Our Ref: E3084-JML20-060068

E3084: Sandstone Precinct, Education Building
Subcontract No: 200996-D&C-011
Changes to MOD 9

As advised by Built, changes to the MOD 9 have occurred which will be incorporated into the latest design. The following list highlights those changes which are Architectural or Building Performance requirements that will require the External Façade works provided by JMLC to be adjusted to suit.

01 EDUCATION BUILDING - PROPOSED WEST ELEVATION
1:200

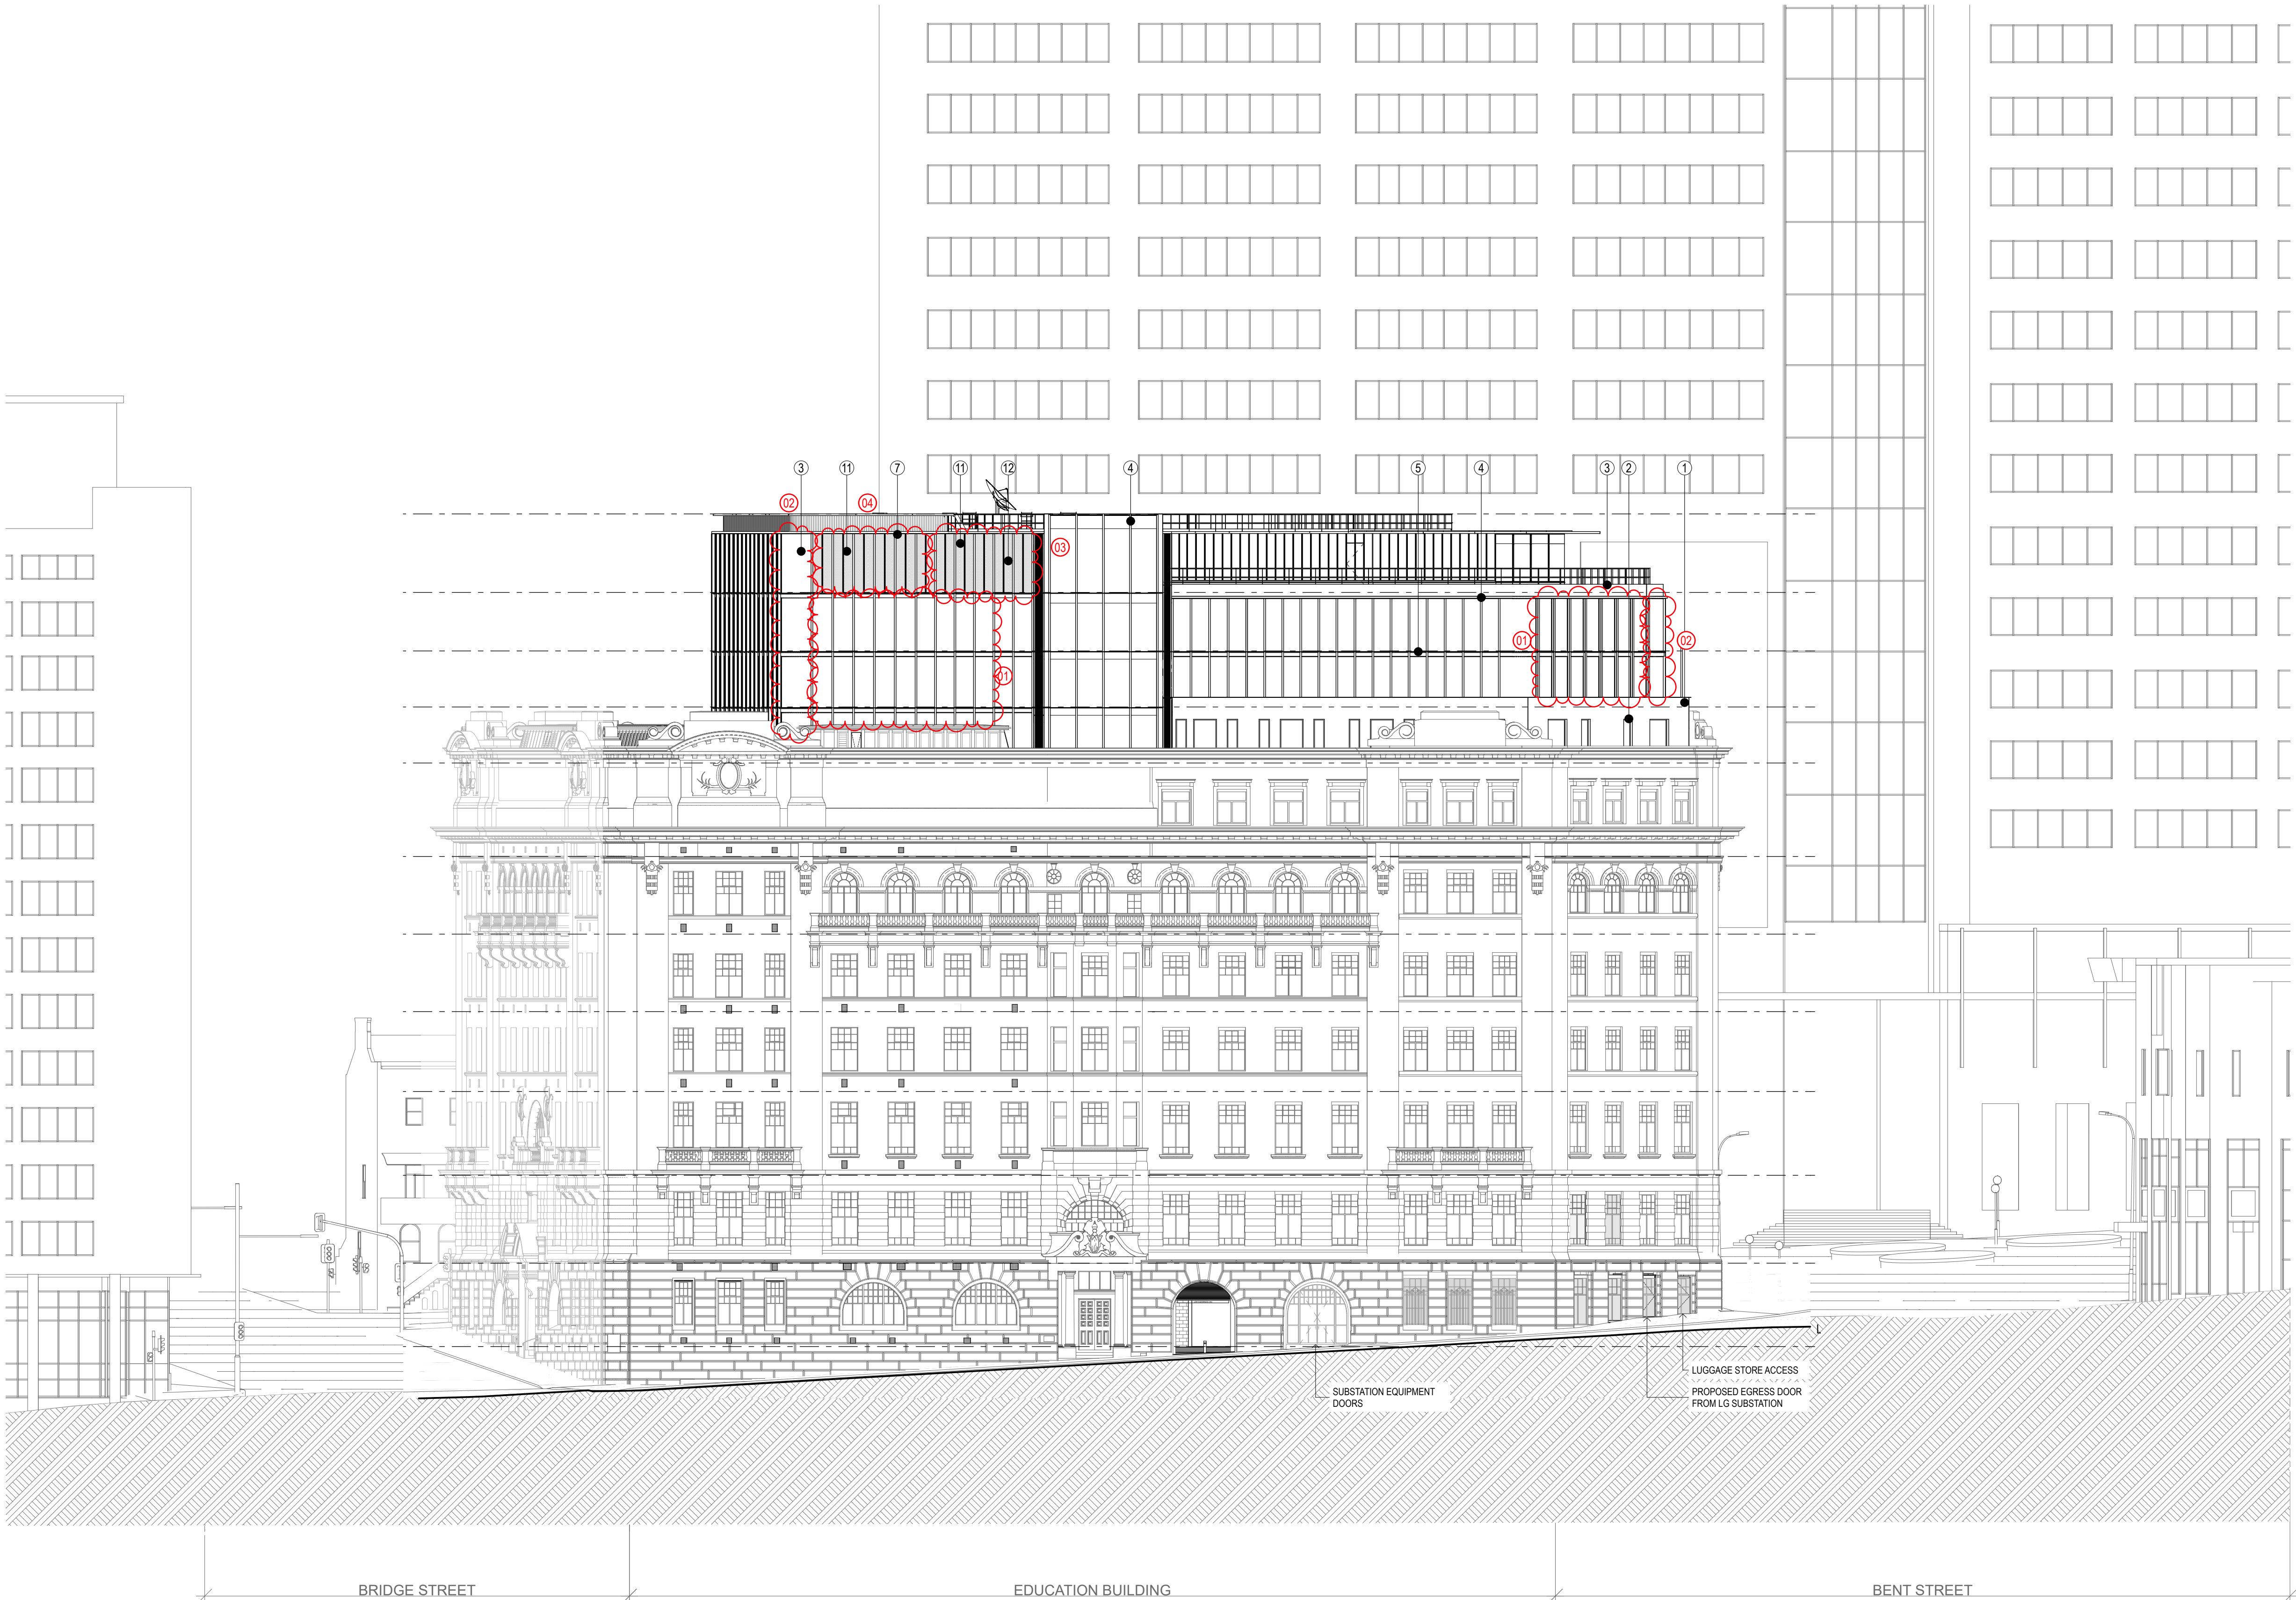
4. The louvres on level 9 Western elevation of the courtyard (FTE09) have been replaced by glass spandrels to maintain design intent in the courtyard. They have relocated to the external elevation of the external façade (FTE11 – Loftus Street face) and are covered by perforated fluted cladding to conceal the mechanical louvres.

TITLE
PROPOSED ELEVATIONS - EDUCATION BUILDING - COURTYARD

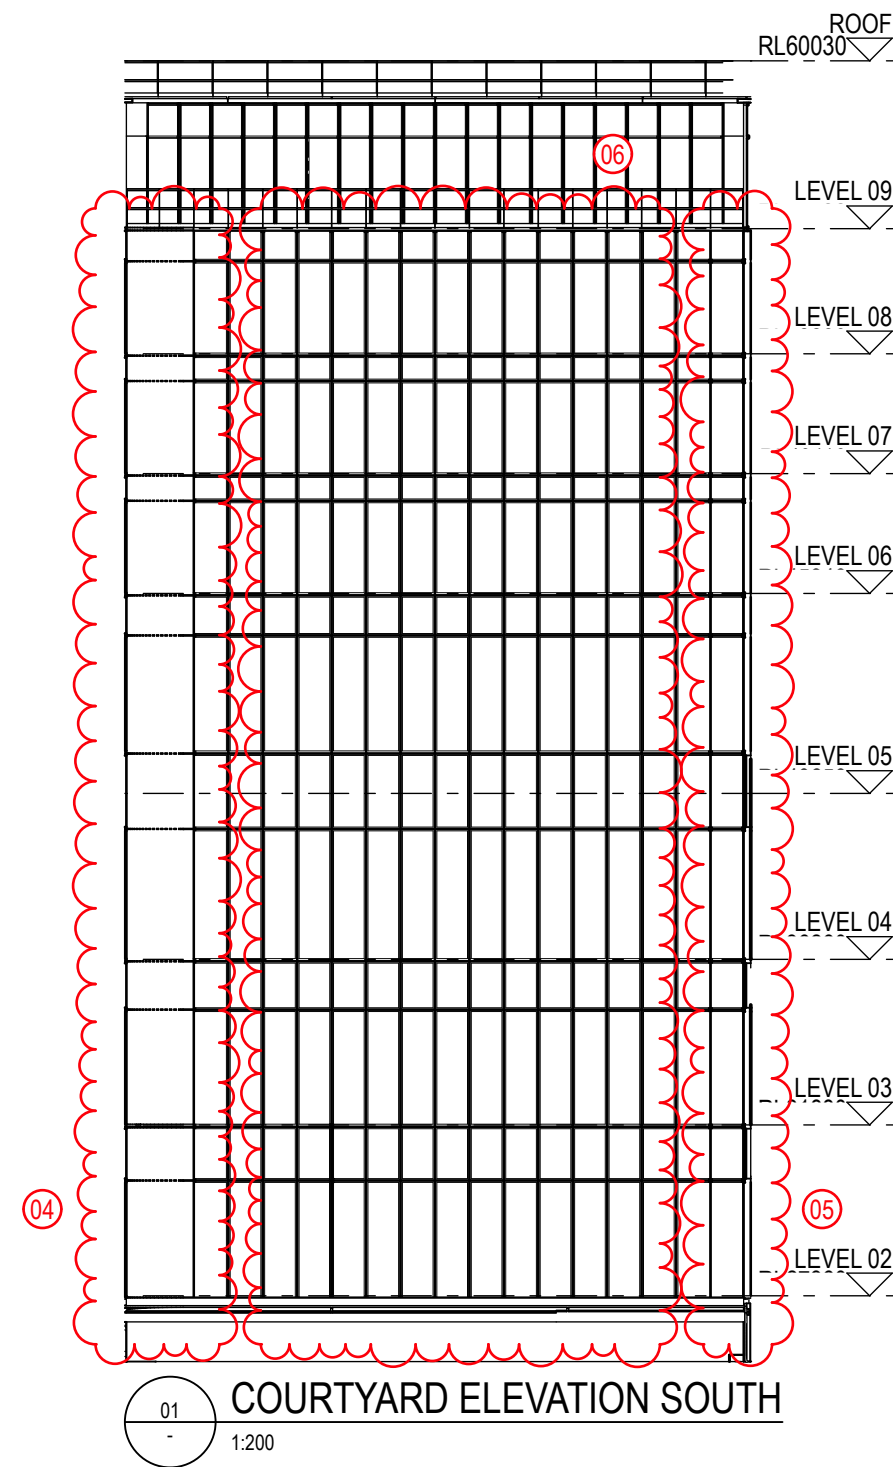
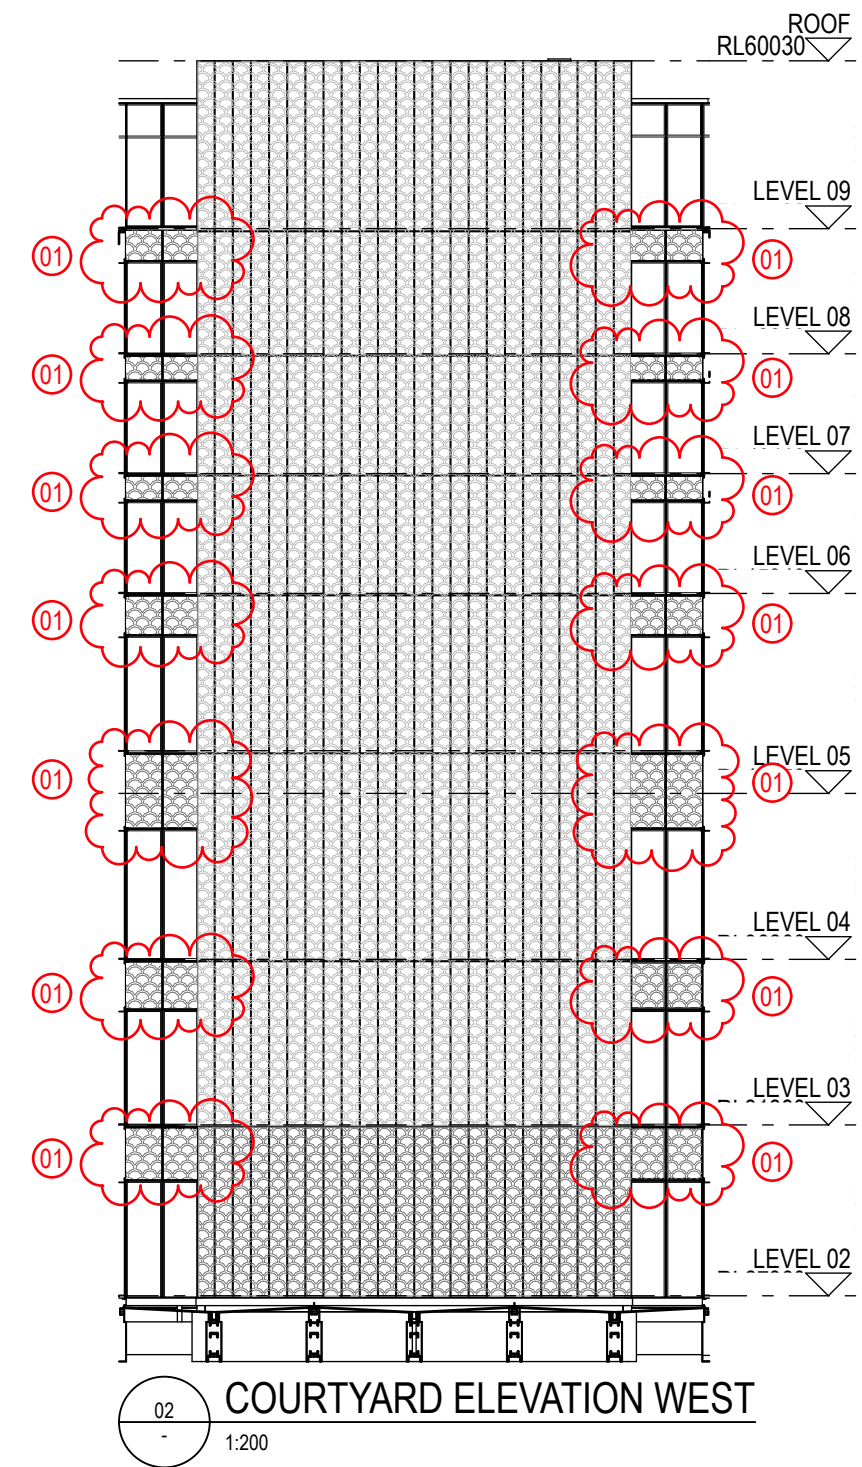
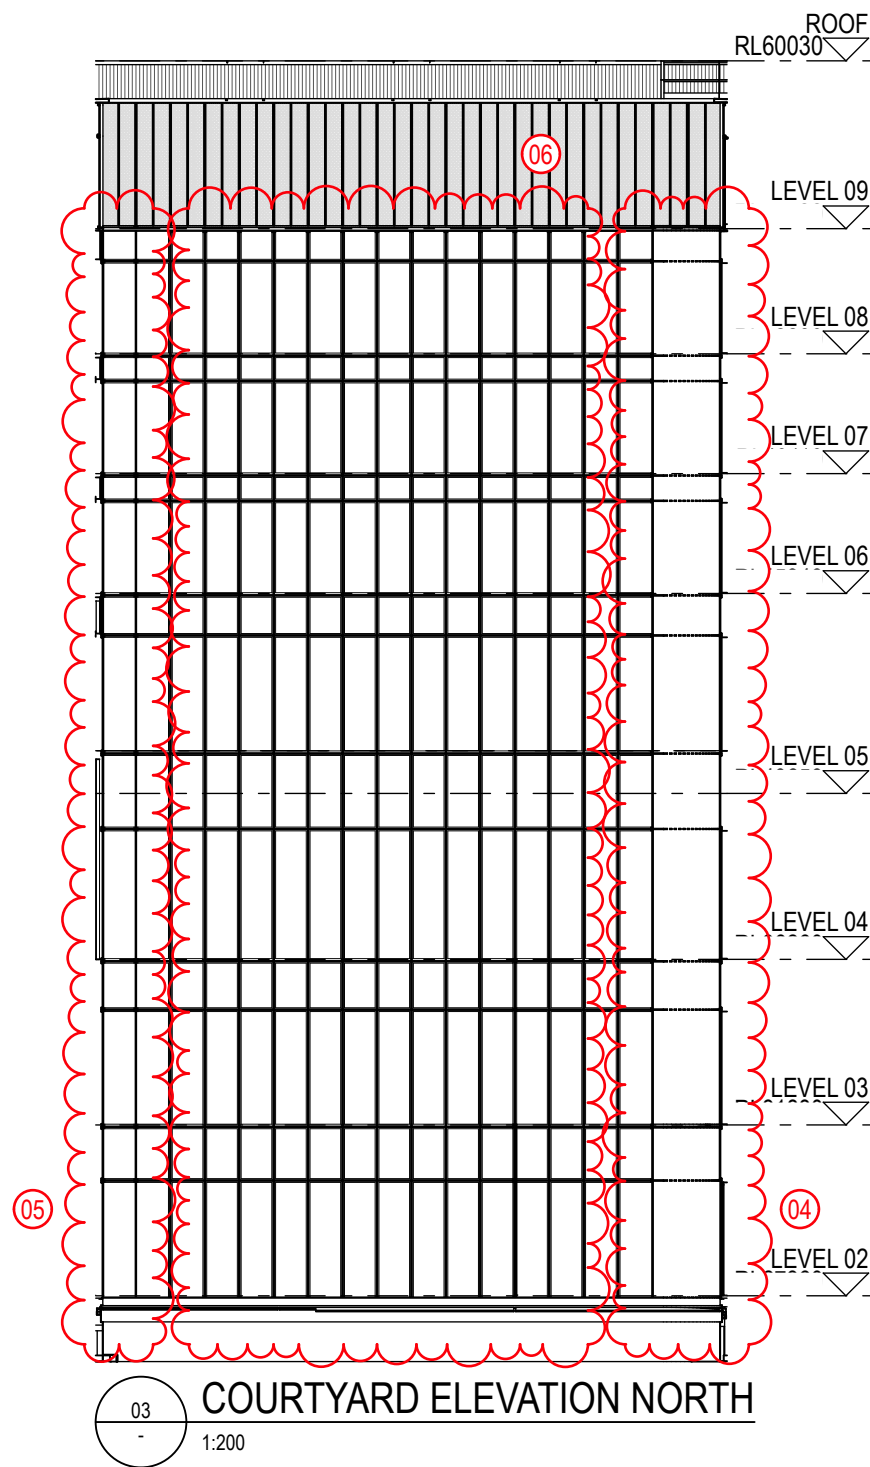
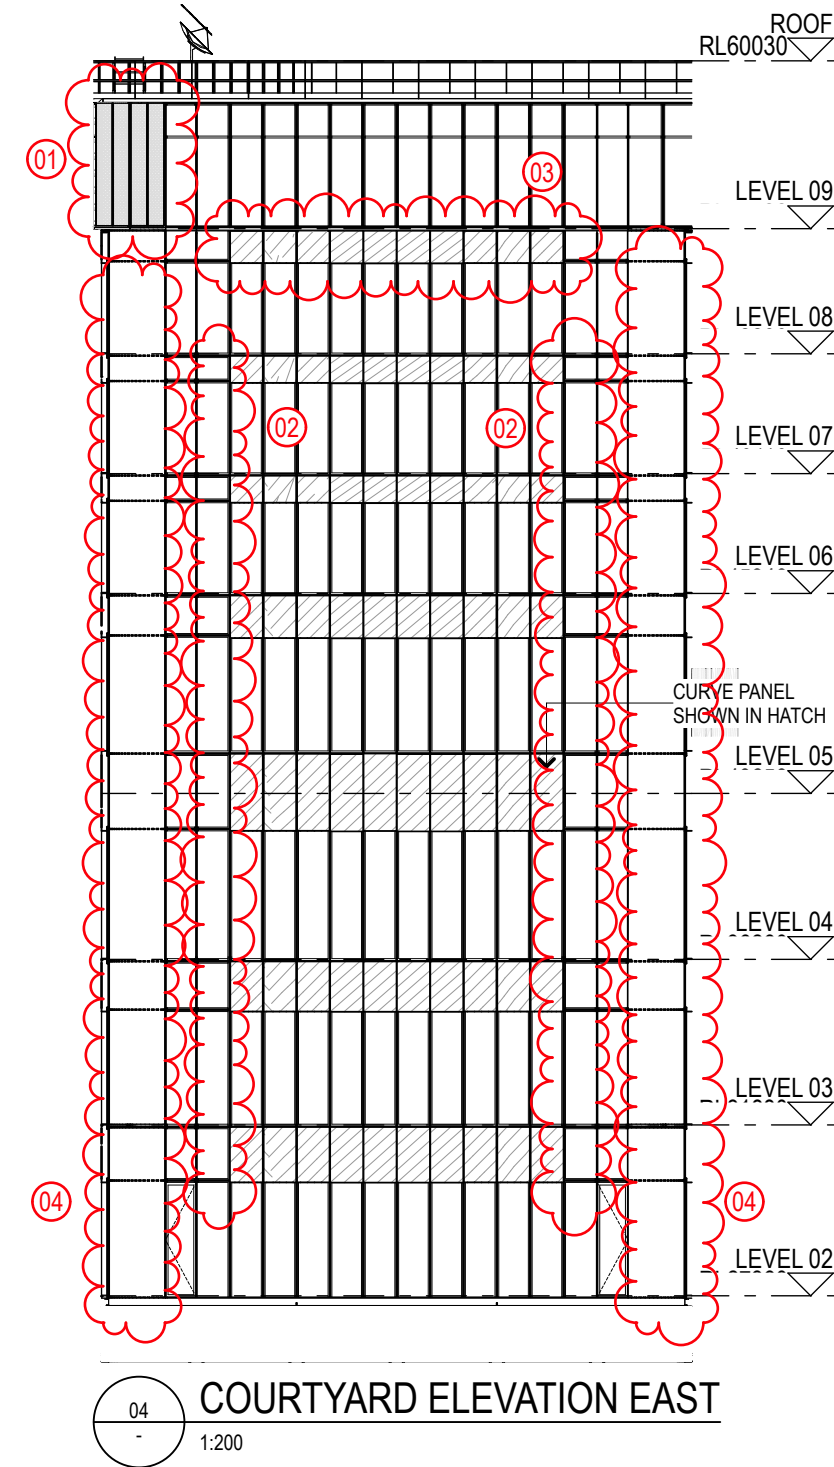
1. The louvres adjacent to the guest lift core (FTE03b) on the West courtyard elevation have been recessed into the façade and are covered by perforated cladding to conceal the louvres and maintain design intent.

2. The glass spandrels next to the louvres in item 1 (only on levels 5-8 of FTE03b) have changed from glass to recessed louvres covered by perforated cladding in order to match the adjacent louvres and maintain design intent.

3. The remaining glass spandrels next to the guest lift core (FTE03b) on the west courtyard elevation have changed to perforated cladding with backpans behind to retain a consistency in the design of the spandrel panels across the West courtyard façade.

5. The louvres on level 9 East elevation of the courtyard (FTE09) have been replaced by glass spandrels to avoid any visible louvres on the glass facade. To avoid visible louvers on the full height glass facade, the required louvres have been located to the furthest north glass panels of the east elevation. The proprietary mechanical louvres are concealed by perforated fluted cladding which matches the level 9 cooling tower facade adjacent.

6. Two awning panels have been removed on every level on the East courtyard elevation from levels 2-

7 (one on each side of current awnings – 2 awnings on 6 levels = 12 awning panels removed) and a new awning consisting of 10 panels has been introduced. In order to retain the same design language as the lower levels and to complete the 'mirrored' glass box concept' an awning was introduced to level 8.

7. The louvres on level 2 of the Eastern elevation of the courtyard (FTE03b) have each moved one panel to the right to create symmetry and even airflow through the level 2 corridor.

10. Louvres have been introduced to the Northern and Southern faces of the guest lift core from levels 5-9 due to design development for air flow purposes and are covered behind perforated cladding to conceal the mechanical louvres and match the design of the East face of the lift core on level 2.

11. The internal corners of the courtyard on the west elevation have changed from curved glass corners to squared glass corners as the 1500mm curved glass radius would have clashed with the louvres.
